Appeal Decision

Appeal Ref: APP/R5510/W/25/3363649

1 Alpha Road, Hillingdon, Uxbridge UB10 0QP

3D Views from outside and inside
demonstrating how the blinkers would work to
show that **neighbours private amenity
spaces would not be visible** from the
proposed rooms

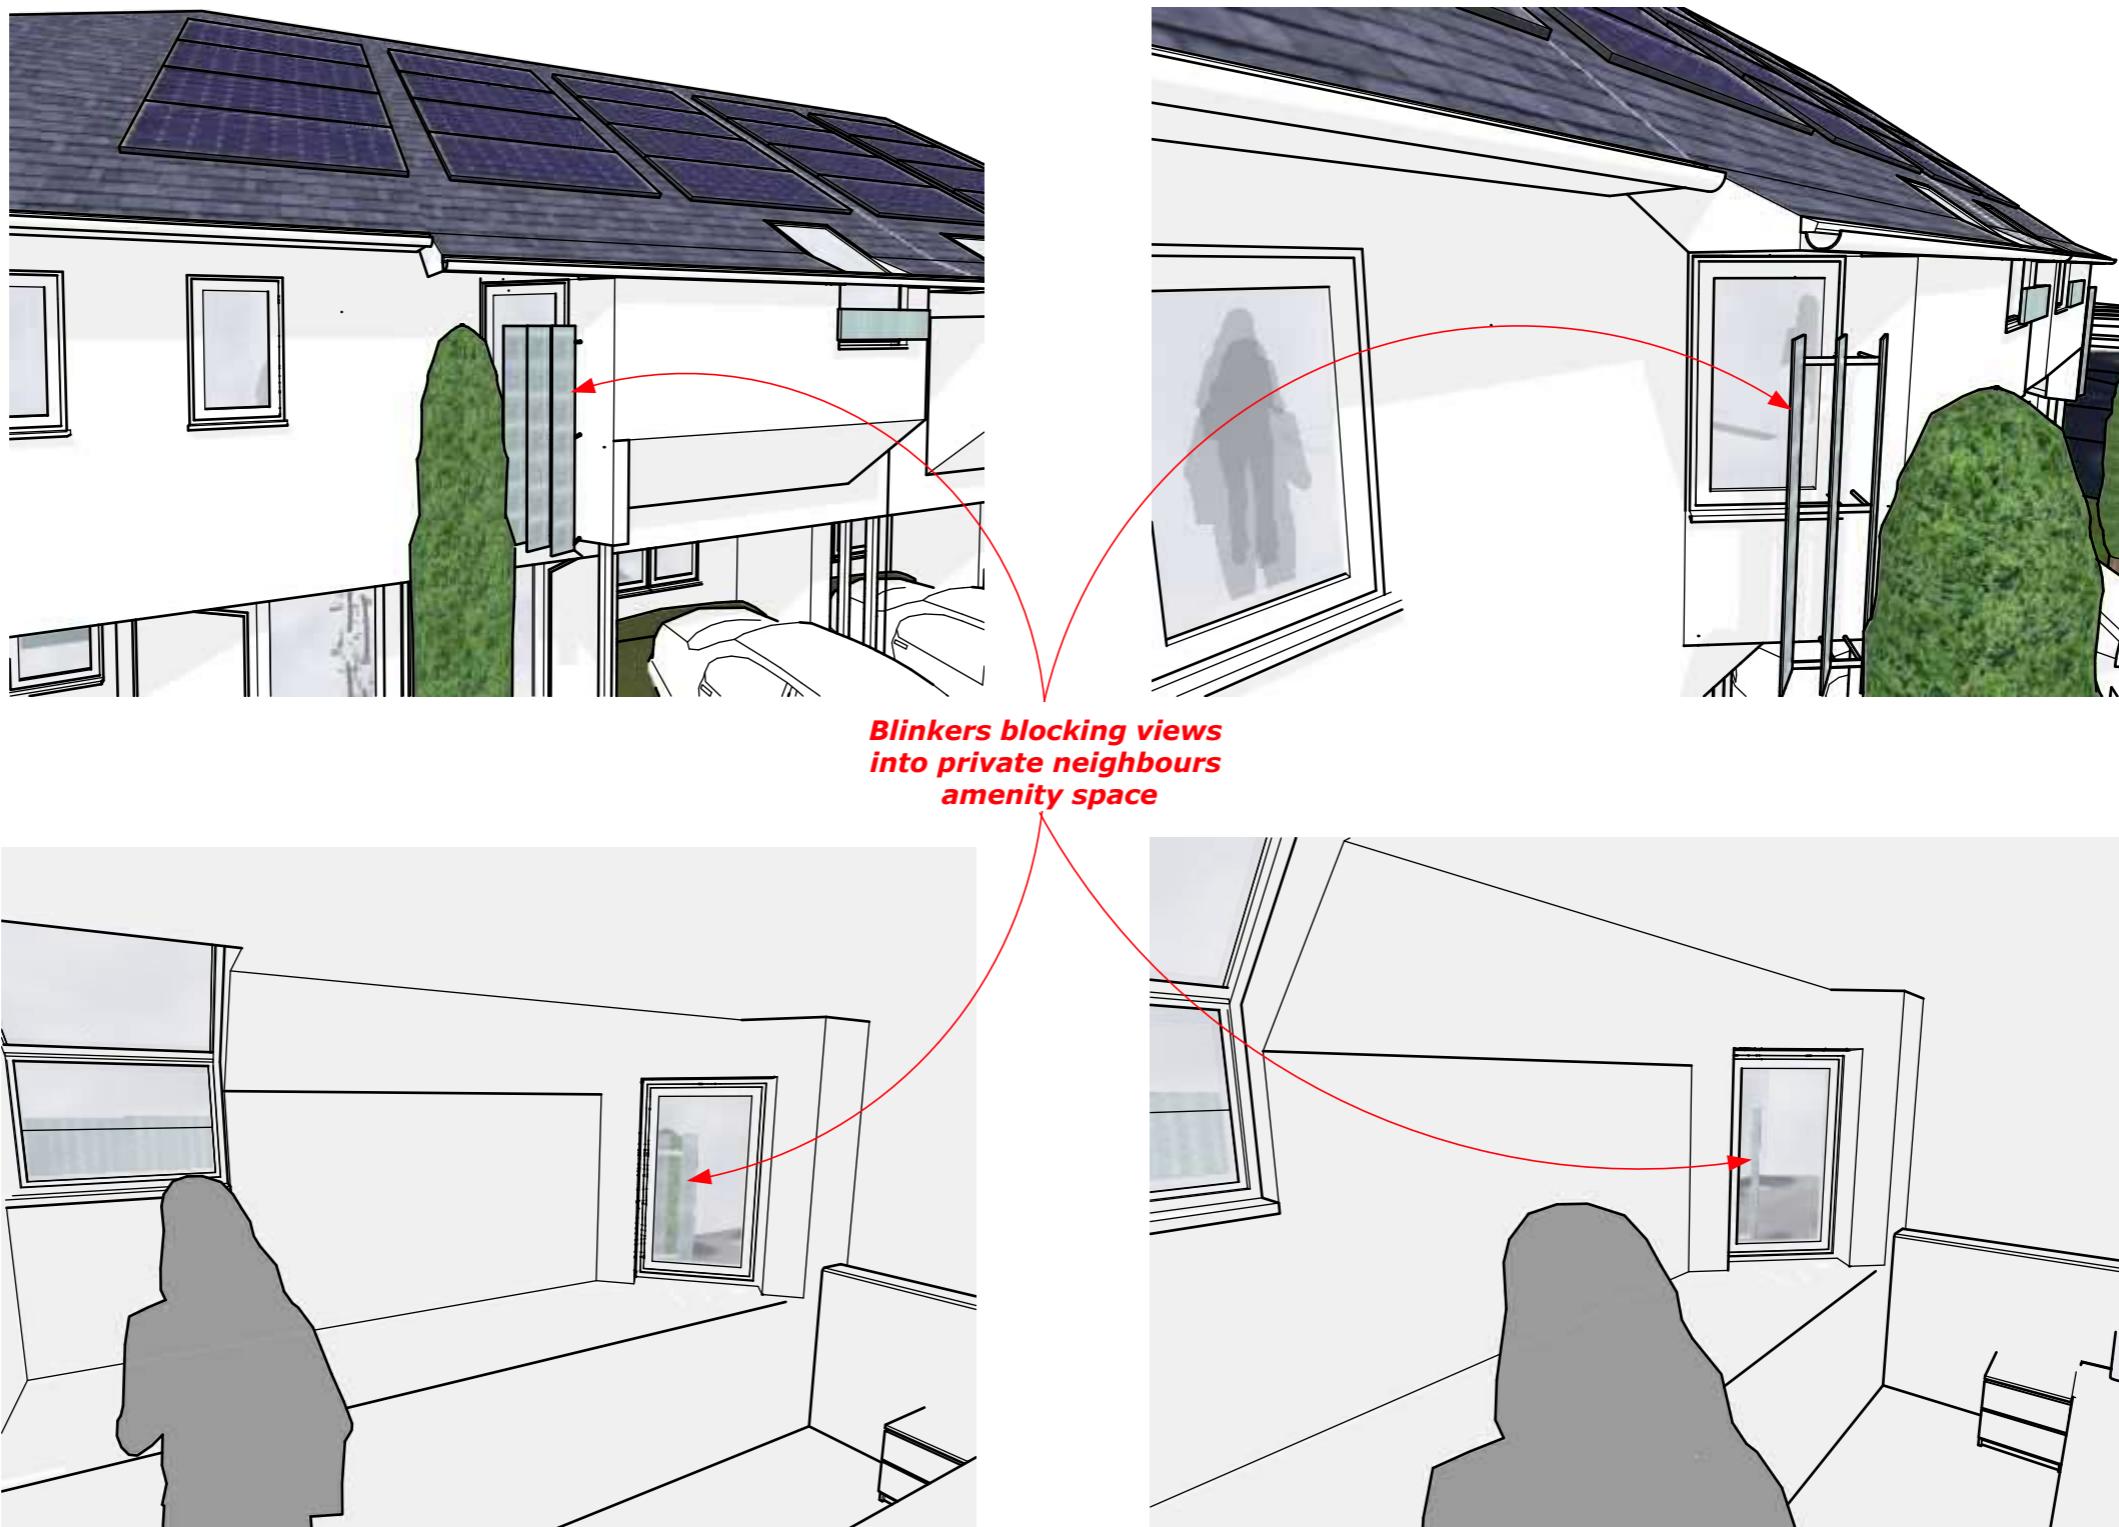
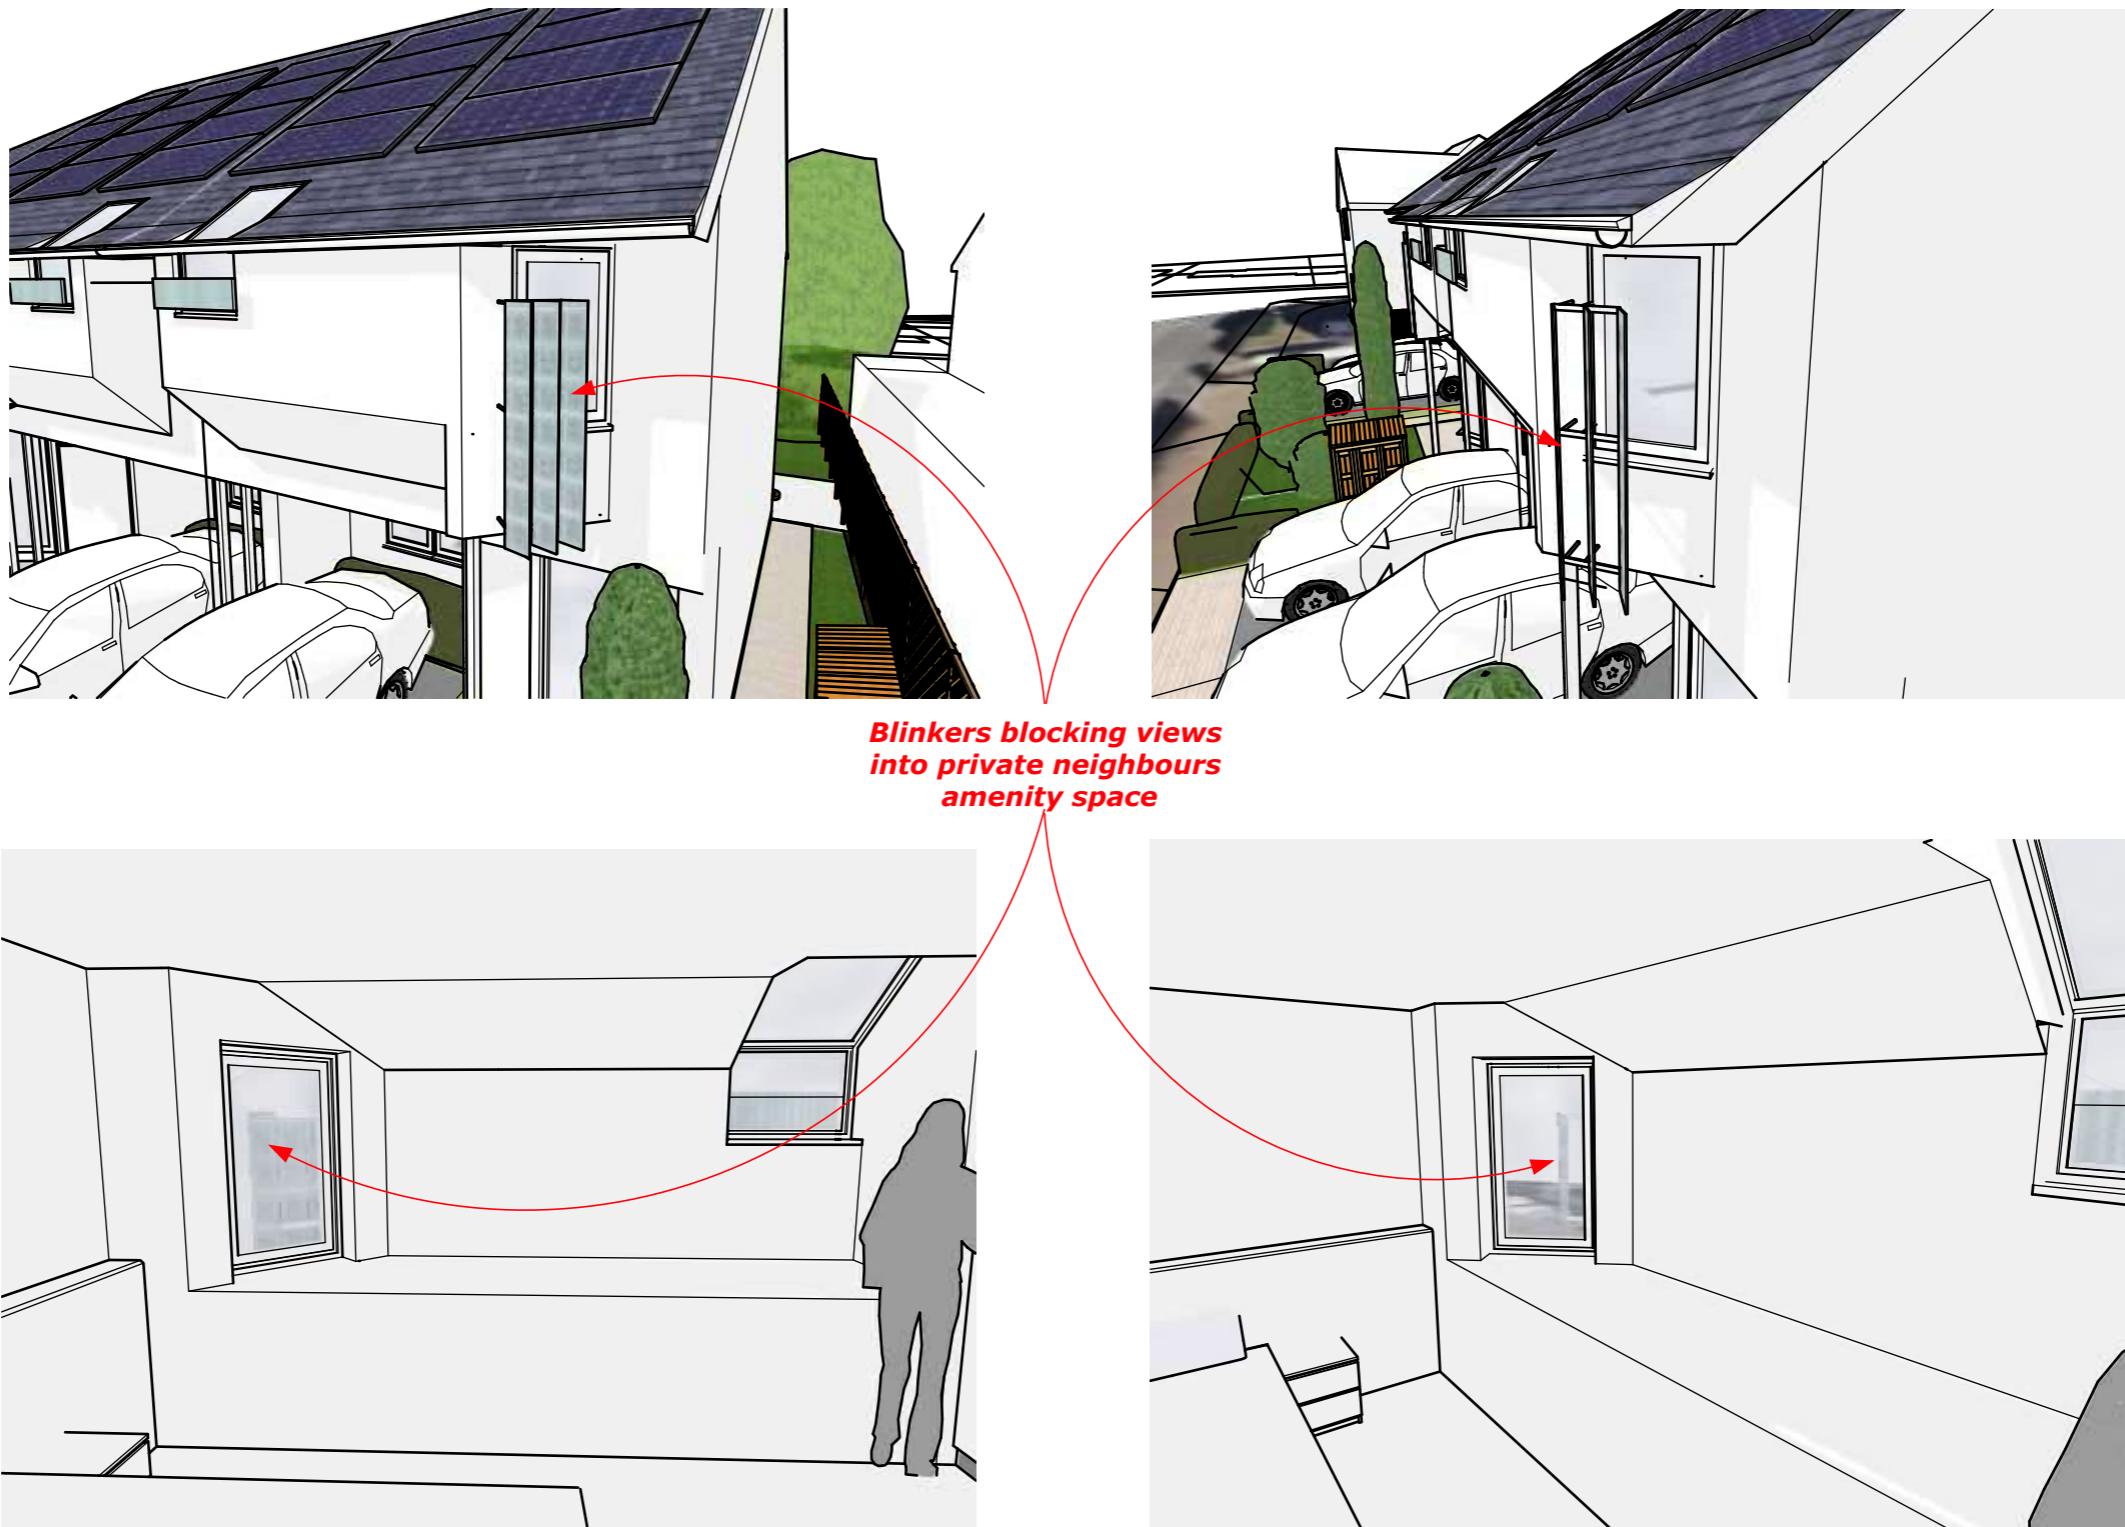
15. Outlook from windows would be constrained by the positioning of windows to first floor bedrooms. The windows to the front of the one bedroom homes would be curtailed by the arrangement of the windows and screens. Even so, these offer two openings to these rooms and I am satisfied that these would offer sufficient light. The outlook would be limited but the occupants would still have vantage outdoors which offers a limited, but nevertheless satisfactory, outlook.

As Proposed
Perspective Views

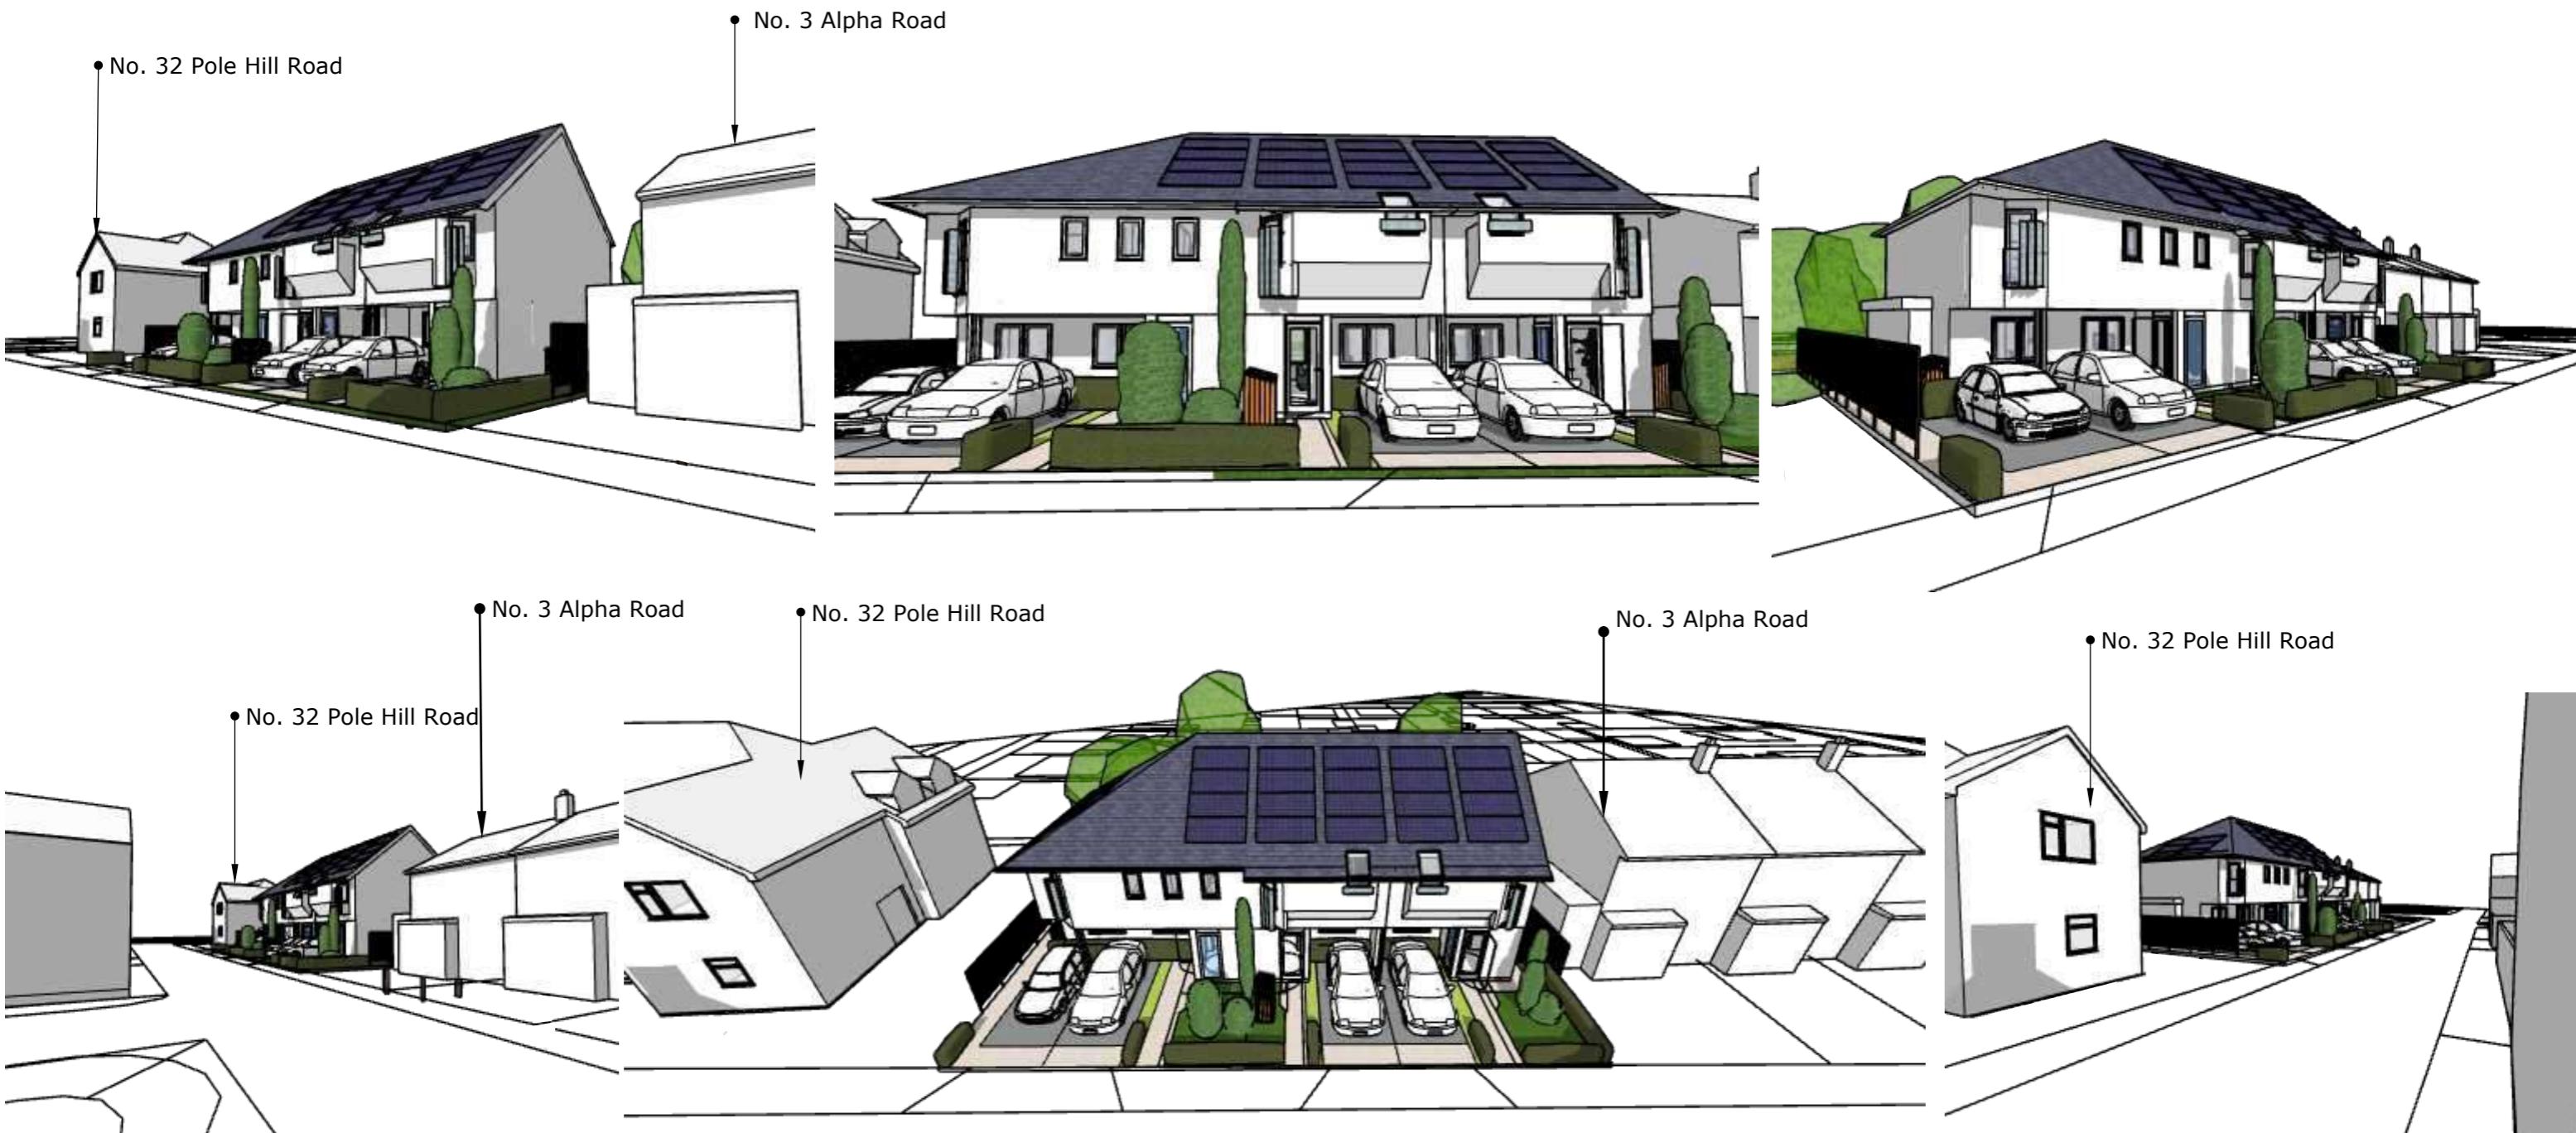
5. The proposal comprises a terrace of three homes that would be set under a pitched roof; hipped to one end and a gable to the other. The upper floor would feature overhanging elements to the front of varying depths, some of which are staggered, and windows of varying sizes and arrangement, some of which break through the eaves. At the rear, first floor windows would project out and be set at an angle.

6. The roof form, projecting elements, window positioning, overhangs and general arrangement give the building a discordant appearance. Prominent features such as the overhangs and roof form lack rhythm or detailing. The building fills much of the width of its plot but nevertheless still appears squat under the large roof. The complex front elevation jars notably with the otherwise simple form of homes in the area. The overall impression given is that an excessive amount of built form is being inserted onto a small plot of land and design contrivances, albeit creative, have resulted from this and these do not benefit the character of the area.

8. I conclude that the proposal would fail to integrate with its surroundings, appearing as a cramped and confused looking building that would be harmful to the character and appearance of the area. As such, the proposal conflicts with policy BE1 of the Hillingdon Local Plan Part 1 Strategic Policies 2012 (HLPSP), policies DMHB11 and DMHB12 of the Hillingdon Local Plan Part 2 Development Management Policies 2020 (HLPDMP), policy D3 of the London Plan 2021 (LP) and provisions of the National Planning Policy Framework (the Framework). This is insofar as it would not harmonise with the local context.
